DRB Application No.: 07DRB-00588(SBP)  
Project Name: NORTH GATEWAY SUBBD.  
Agent: MULLEN HELLER ARCHITECTURE

2. **Project # 1005545**  
07DRB-00588 Minor-SiteDev Plan  
BldPermit
- MULLEN HELLER ARCHITECTURE agent(s) for FARM CREDIT OF NEW MEXICO request(s) the above action(s) for all or any portion of Tract(s) C-1-A, **NORTH GATEWAY SUBDIVISION**, zoned IP industrial park, located on BALLOON FIESTA PARKWAY NE between SAN MATEO NE and PAN AMERICAN FREEWAY containing approximately 2 acre(s). [REF: DRB-97-6] [Deferred from 5/16/07] (B-18) **DEFERRED AT THE AGENT'S REQUEST TO 05/30/07.**

**DEVELOPMENT REVIEW BOARD  
TRANSPORTATION DEVELOPMENT  
Standard Comment Sheet**

DRB- 1005545                      Item No. 2                      Zone Atlas B-18

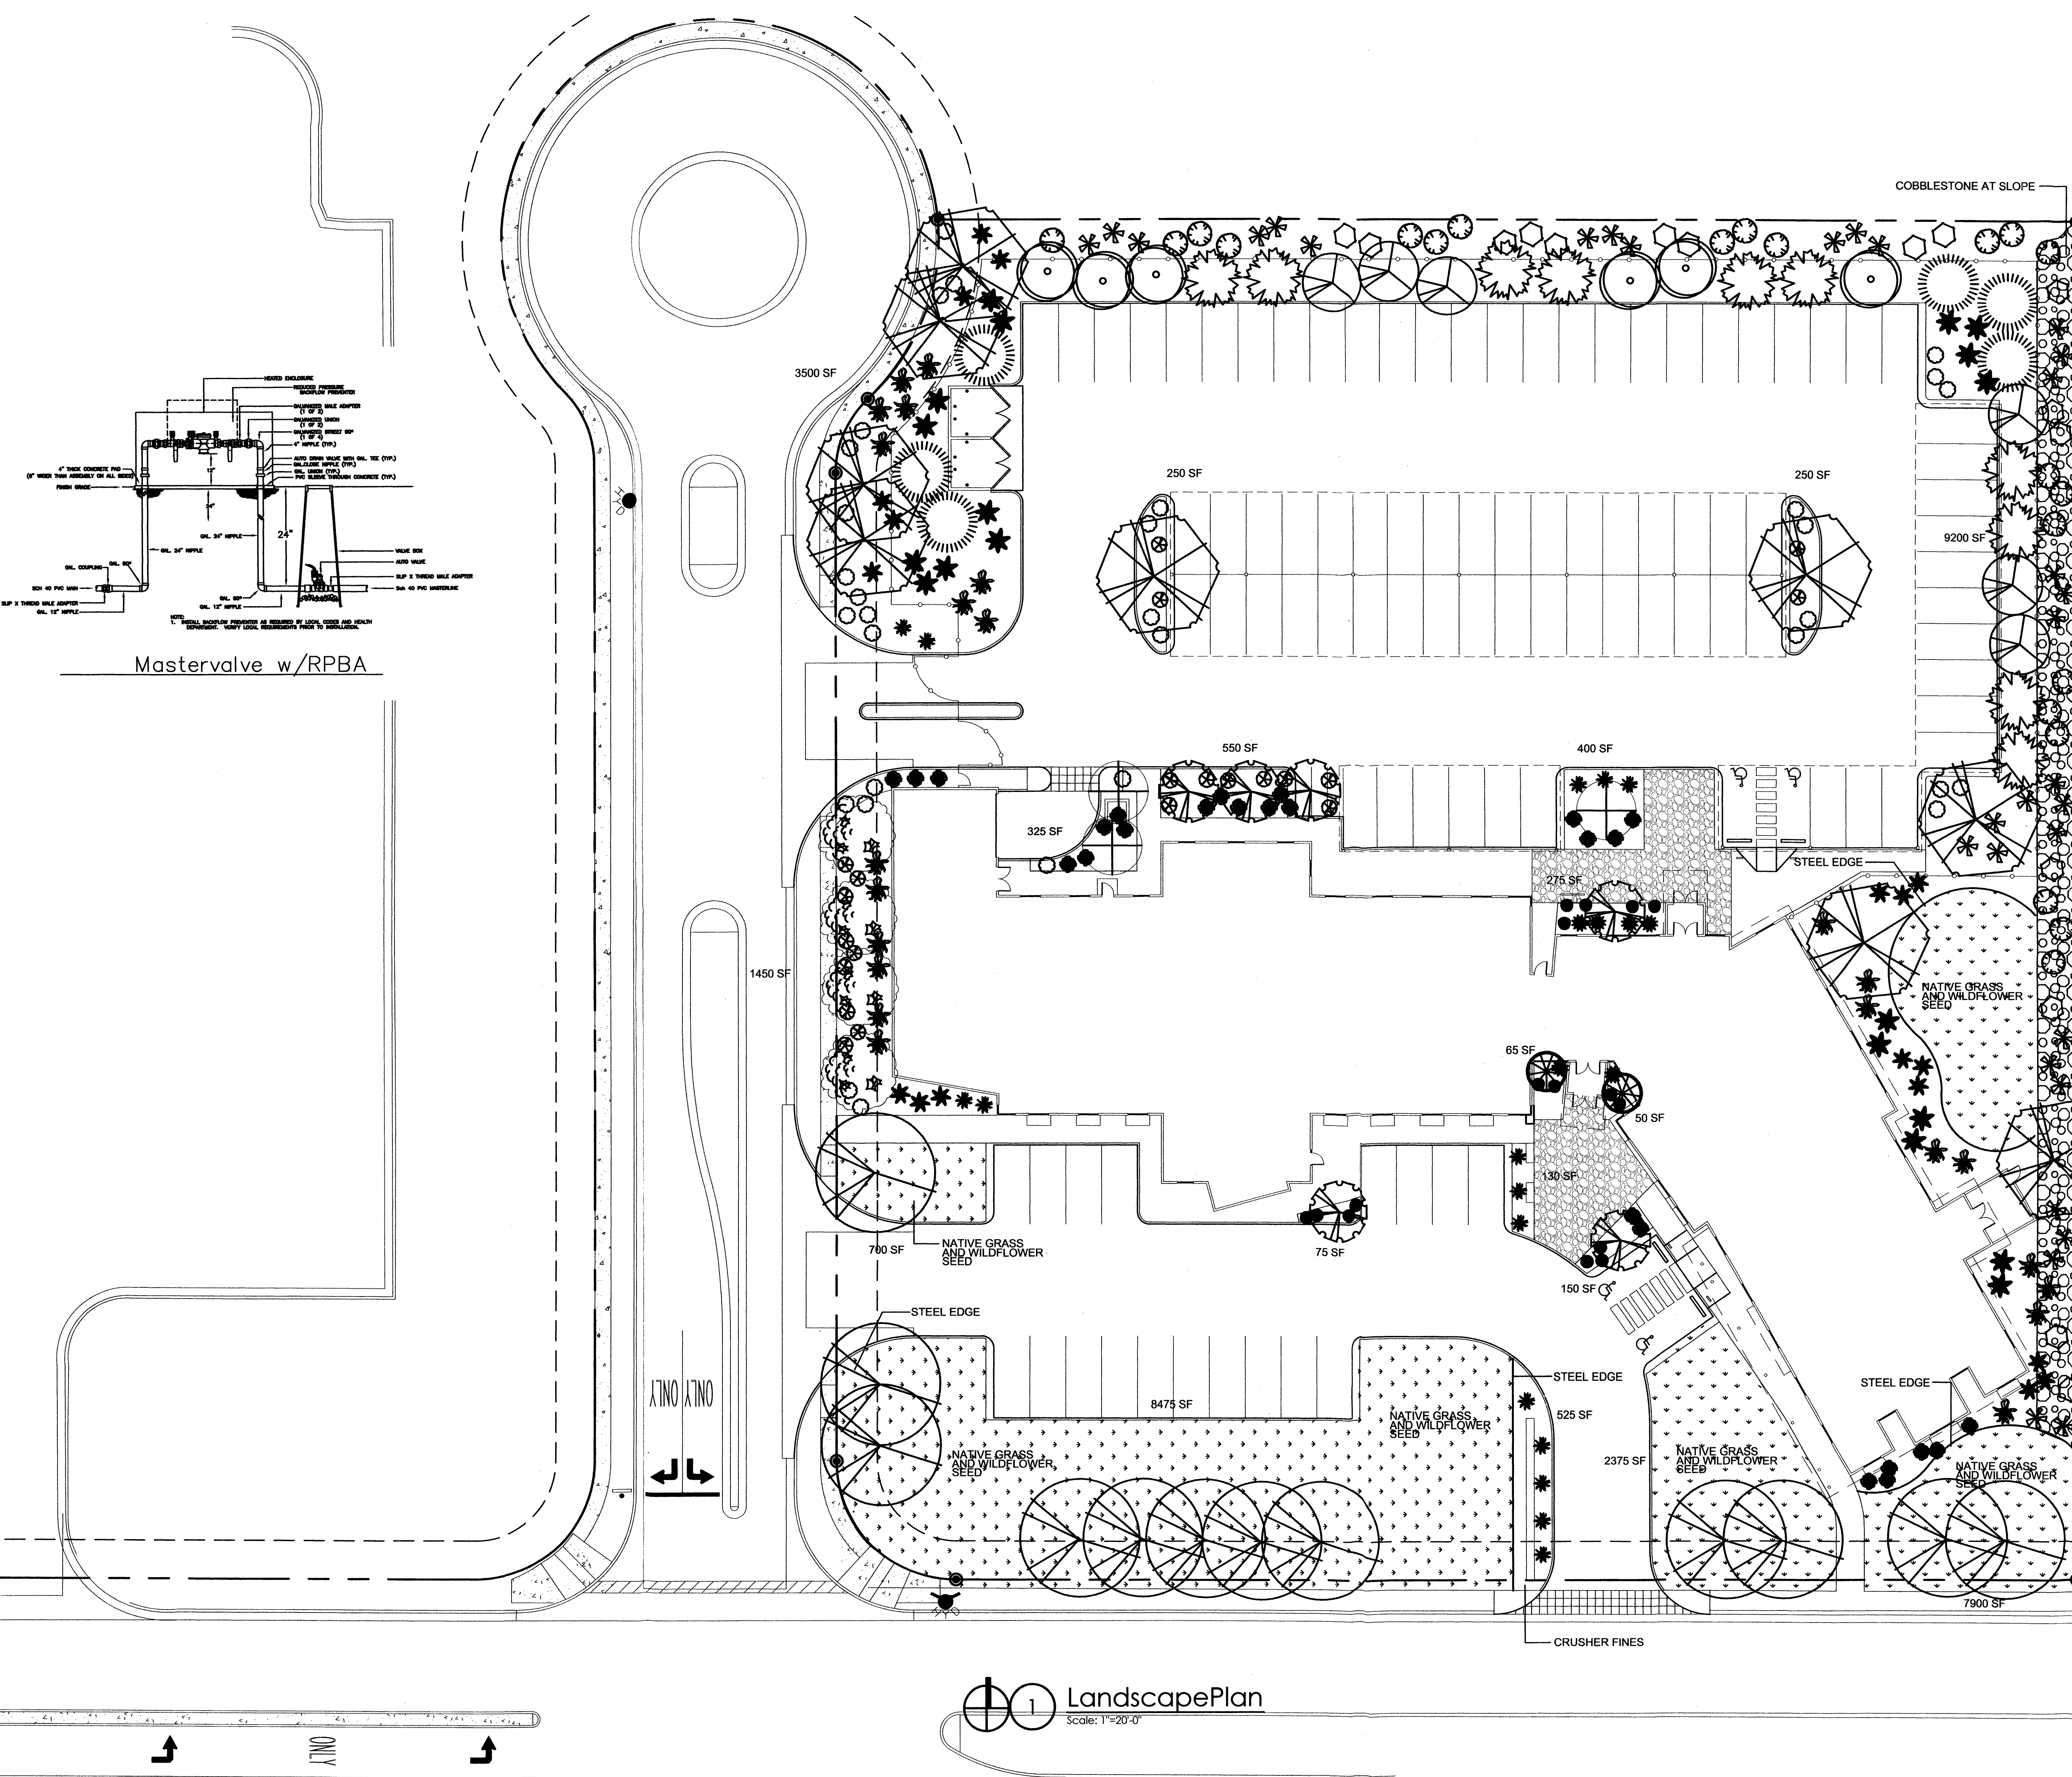
- 1) Why are there medians on Balloon Fiesta Court? The radius is insufficient for having a median. In addition, the lanes will need to be a minimum of 20' if a median is to be constructed.
- 2) Parking bumpers are needed on the south side of the building.
- 3) The drive pad onto Balloon Fiesta Parkway needs to be 30' wide.

- 4) Sight distance around the monument sign needs to be evaluated on Balloon Fiesta Parkway. (Pedestrians will need to be considered.)
